**WELWYN HATFIELD BOROUGH COUNCIL
EXECUTIVE DIRECTOR - PLANNING, PUBLIC PROTECTION AND GOVERNANCE**

Application No: 6/2022/1248/LAWP
Location: Manor Cottage Vineyards Road Northaw Potters Bar EN6 4PQ
Proposal: Certificate of Lawfulness for the erection of a single storey side extension
Officer: Ms Kirsty Shirley

Recommendation: Refused

Drawing Number:
TDC065/ PL/100

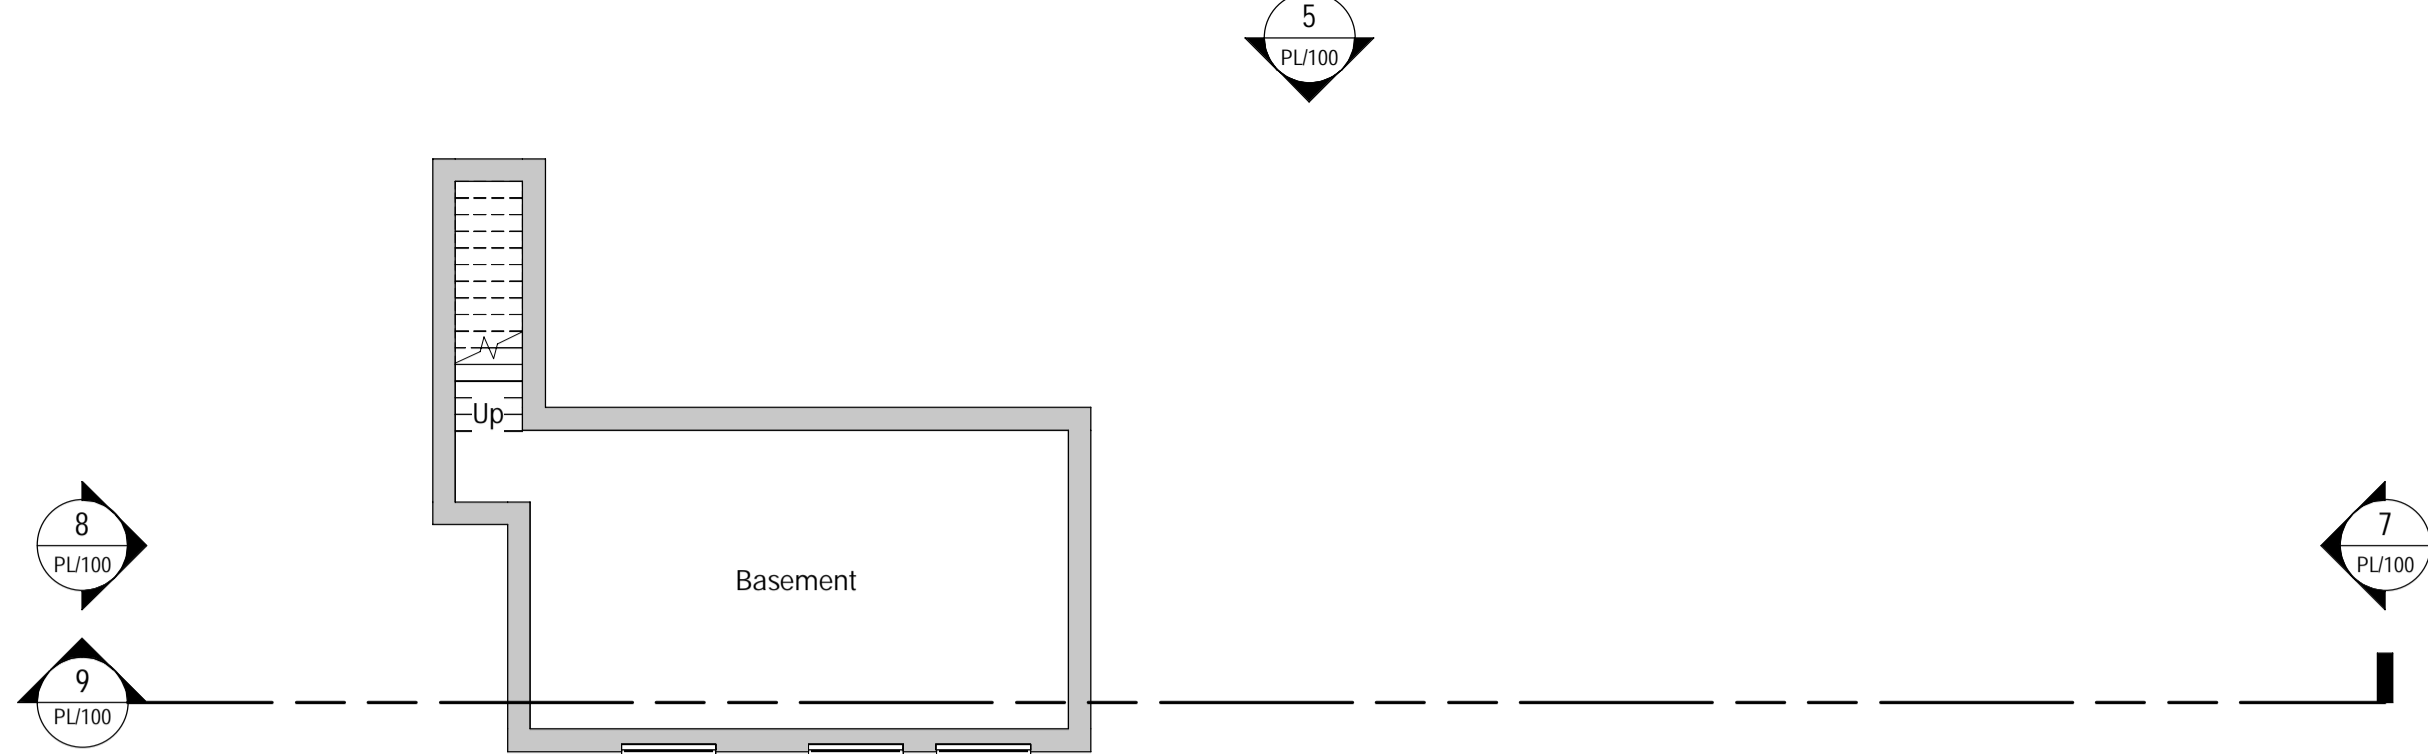
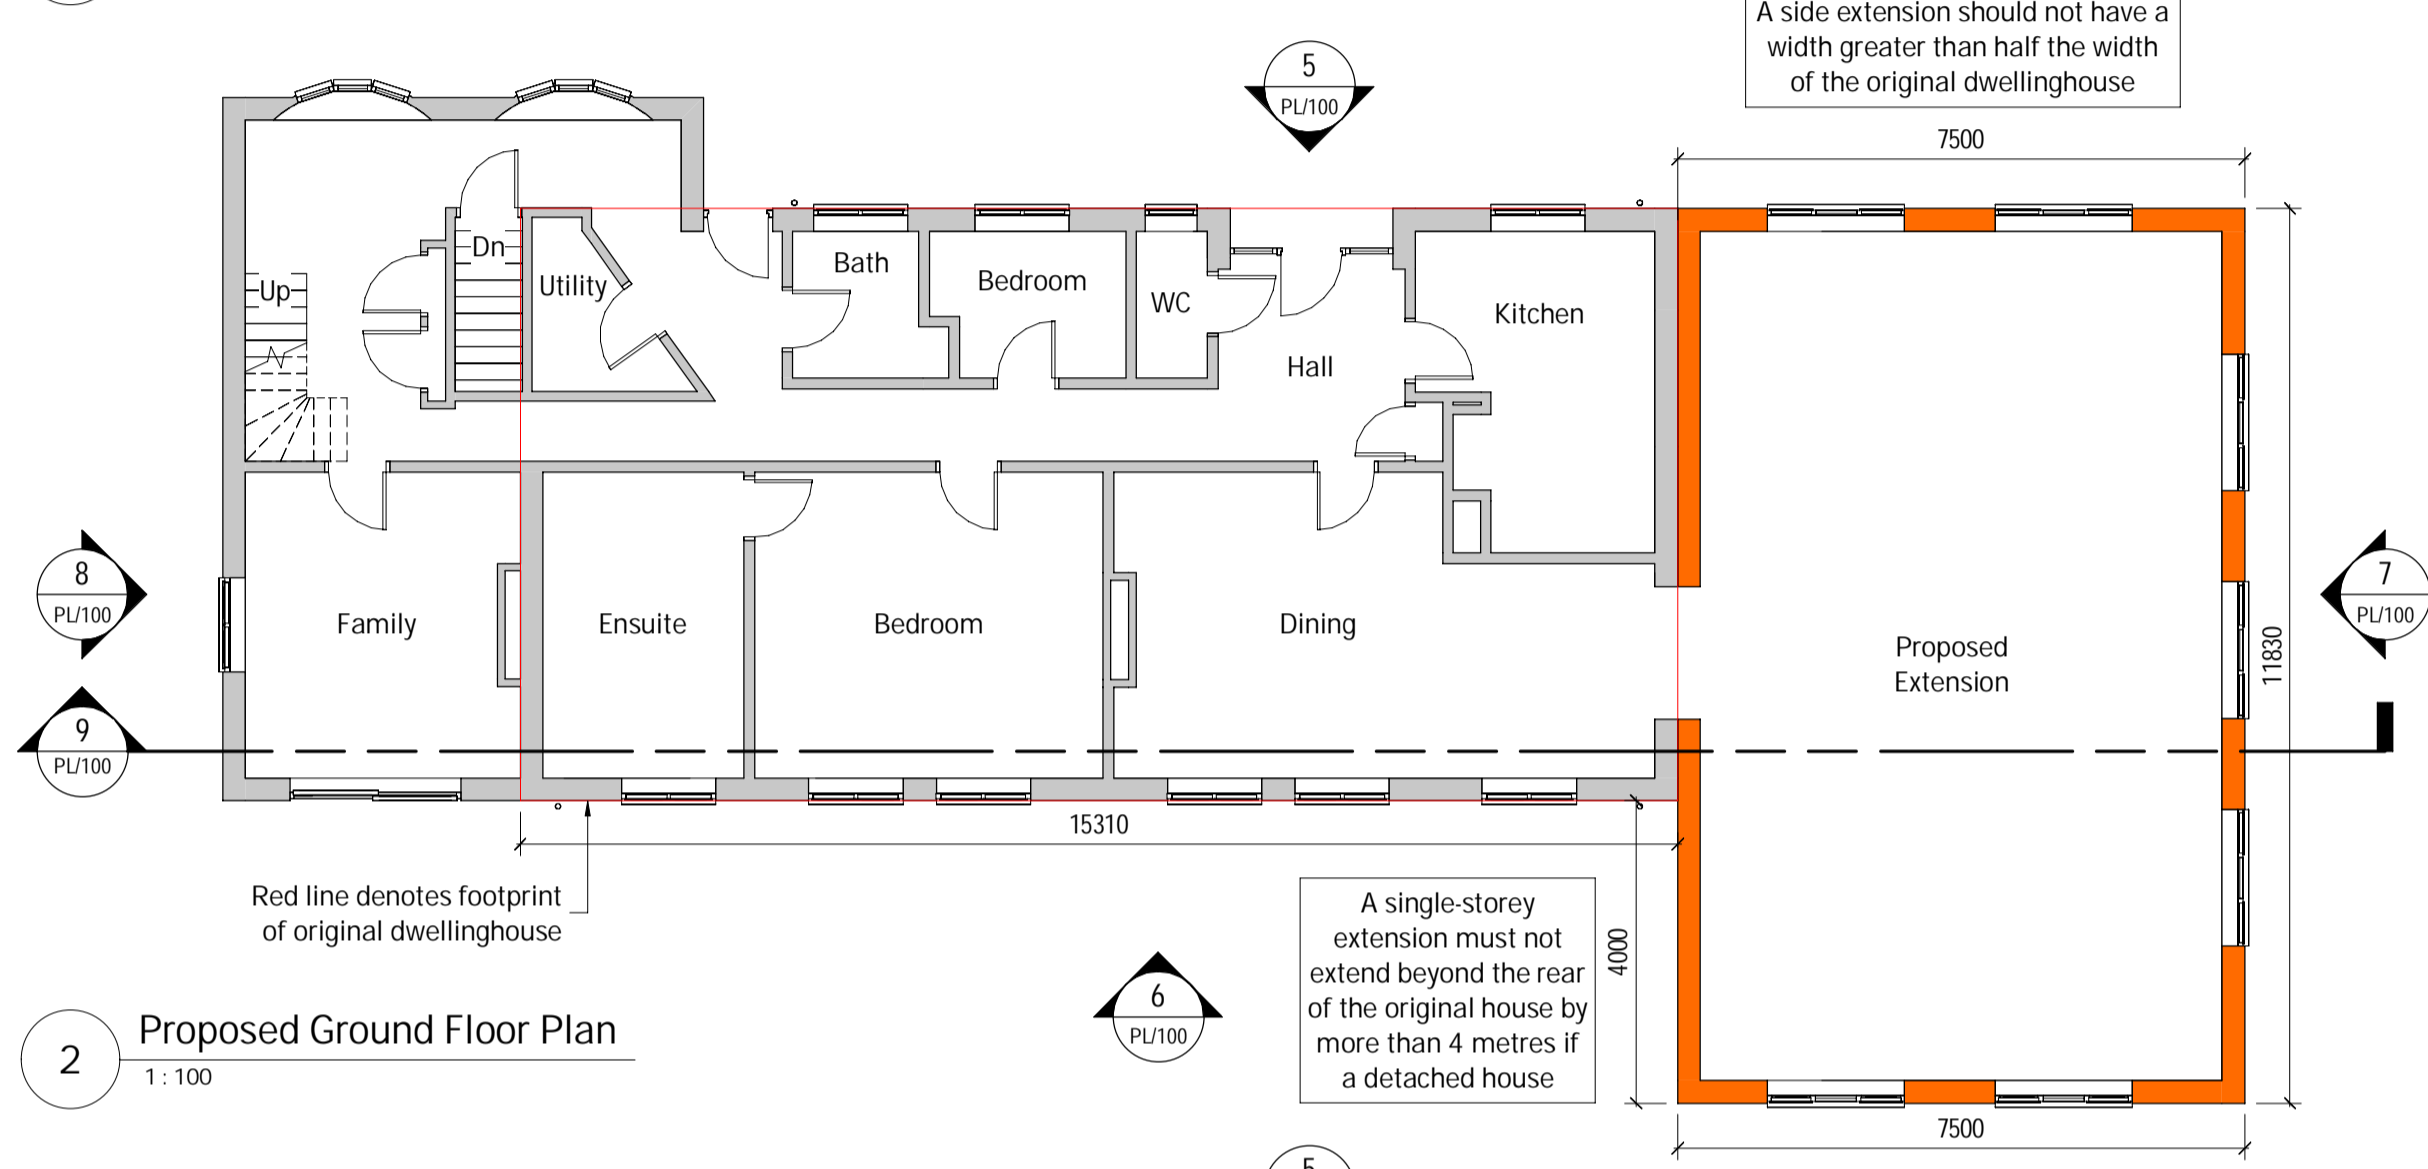
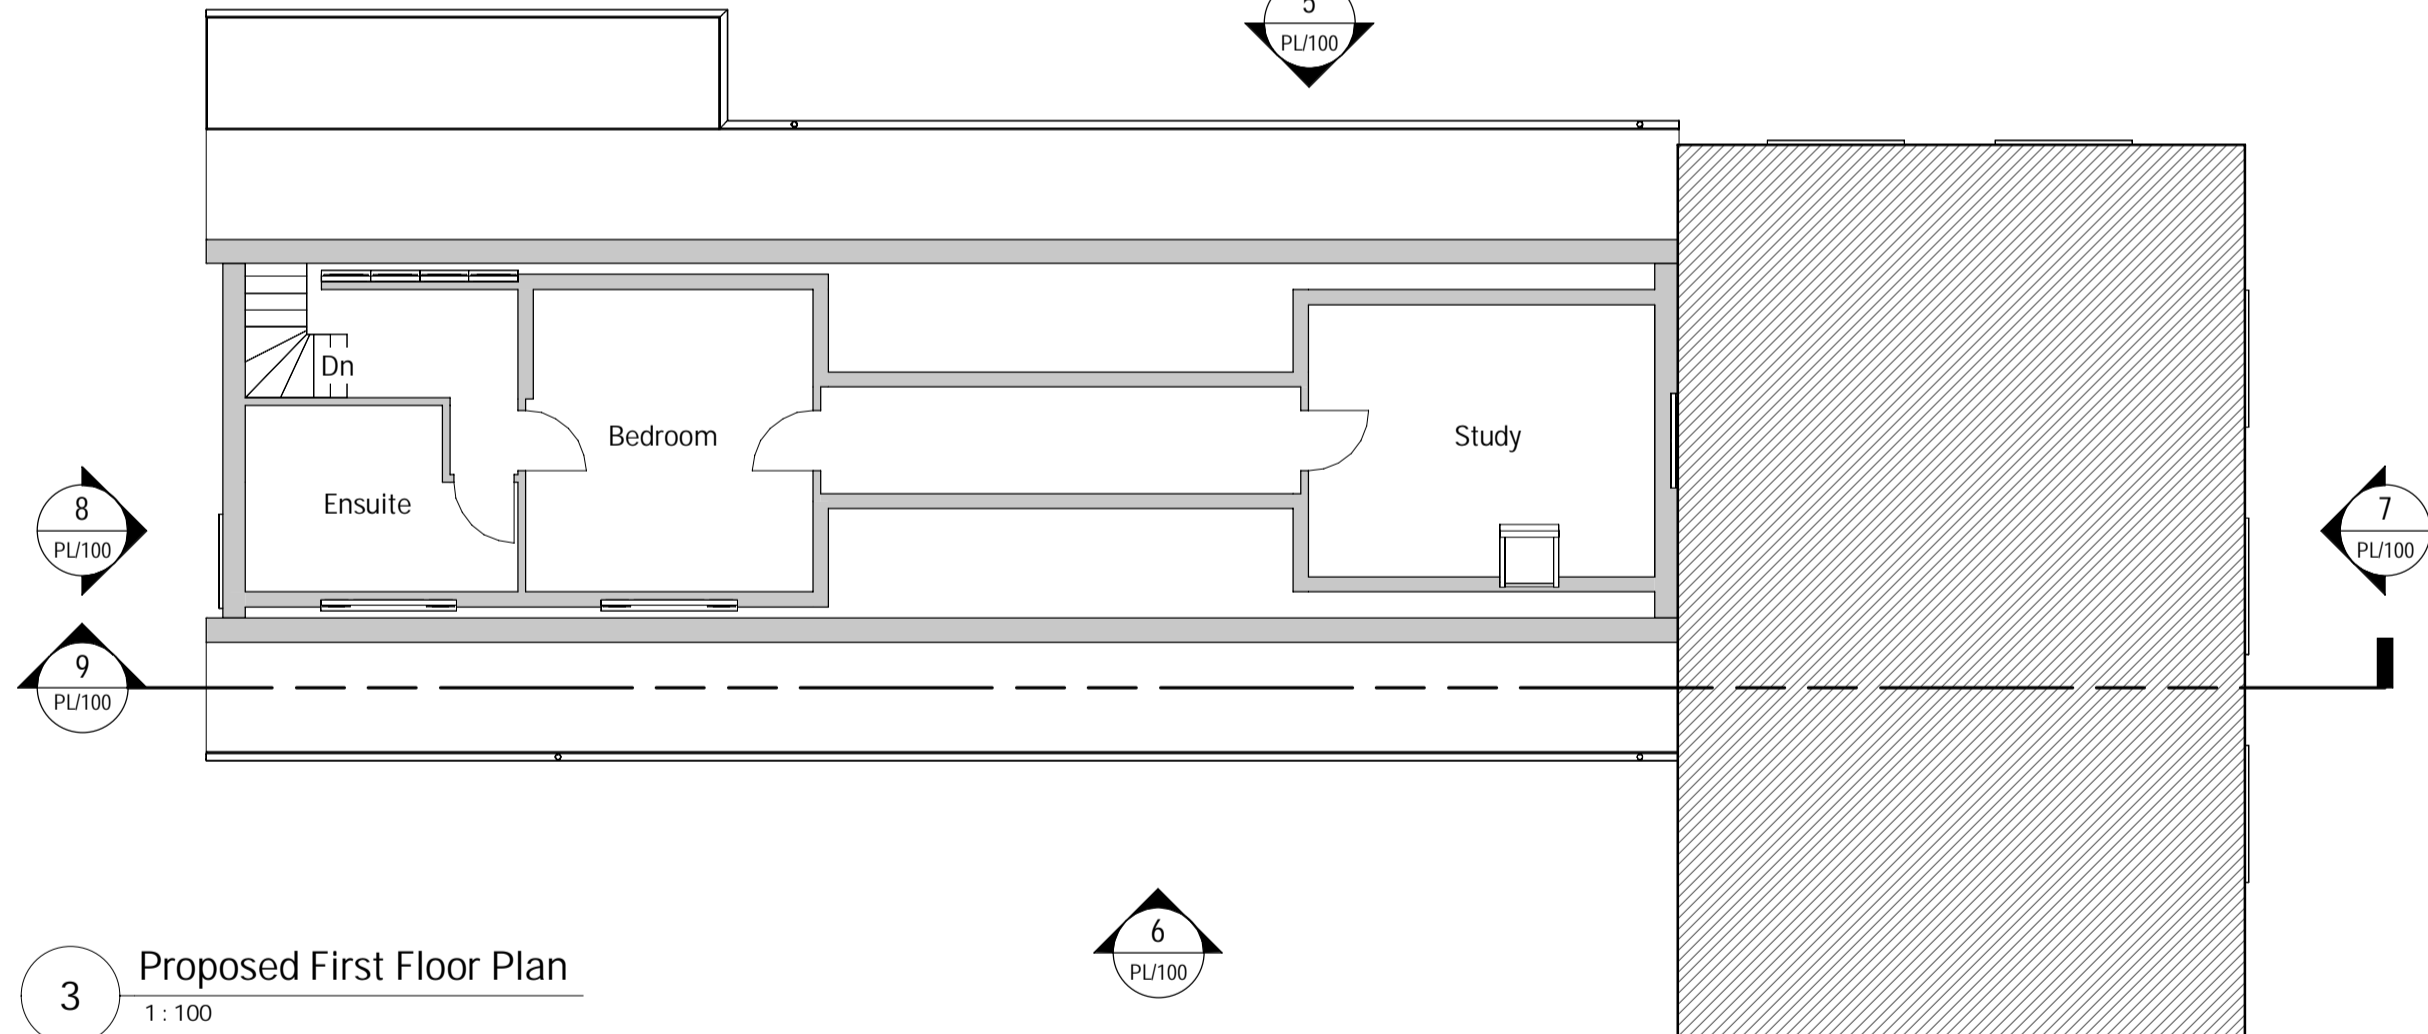
(e) would the enlarged part of the dwellinghouse extend beyond a wall which:- (i) forms the principal elevation of the original dwellinghouse; or (ii) fronts a highway and forms a side elevation of the original dwellinghouse	Y	N

(c) would, where the enlarged part of the dwellinghouse has more than one storey, the roof pitch of the enlarged part, so far as practicable, be the same as the roof pitch of the original dwellinghouse	N/A	N
Discussion		
<p>The Permitted development rights for householders Technical Guidance advises the extent to which an elevation of a house fronts a highway will depend on factors such as:</p> <p>(i) the angle between the elevation of the house and the highway. If that angle is more than 45 degrees, then the elevation will not normally be considered as fronting a highway;</p> <p>(ii) the distance between the house and the highway - in cases where that distance is substantial, it is unlikely that a building can be said to front the highway. The same may be true where there is a significant intervening area of land in different ownership or use between the boundary of the curtilage of the house concerned and the highway.</p> <p>The proposed flank elevation of the side extension would directly face Vineyards Road. Furthermore, the flank elevation of the extension would be approximately 20m from Vineyards Road, an insubstantial distance from Vineyards Road with no significant intervening area of land in different ownership or use between the boundary of the curtilage of the application dwelling and Vineyards Road.</p> <p>The proposed development would therefore extend beyond a wall which fronts a highway and forms a side elevation of the original dwellinghouse, failing to meet the criteria of Schedule 2, Part 1, Class A (e) (ii) of the Town and Country Planning (General Permitted Development) (England) Order 2015 as amended.</p>

Conclusion		
<p>The proposed side extension would not meet the criteria of Schedule 2, Part 1, Class A (e) (ii) of the Town and Country Planning (General Permitted Development) (England) Order 2015 as amended.</p>
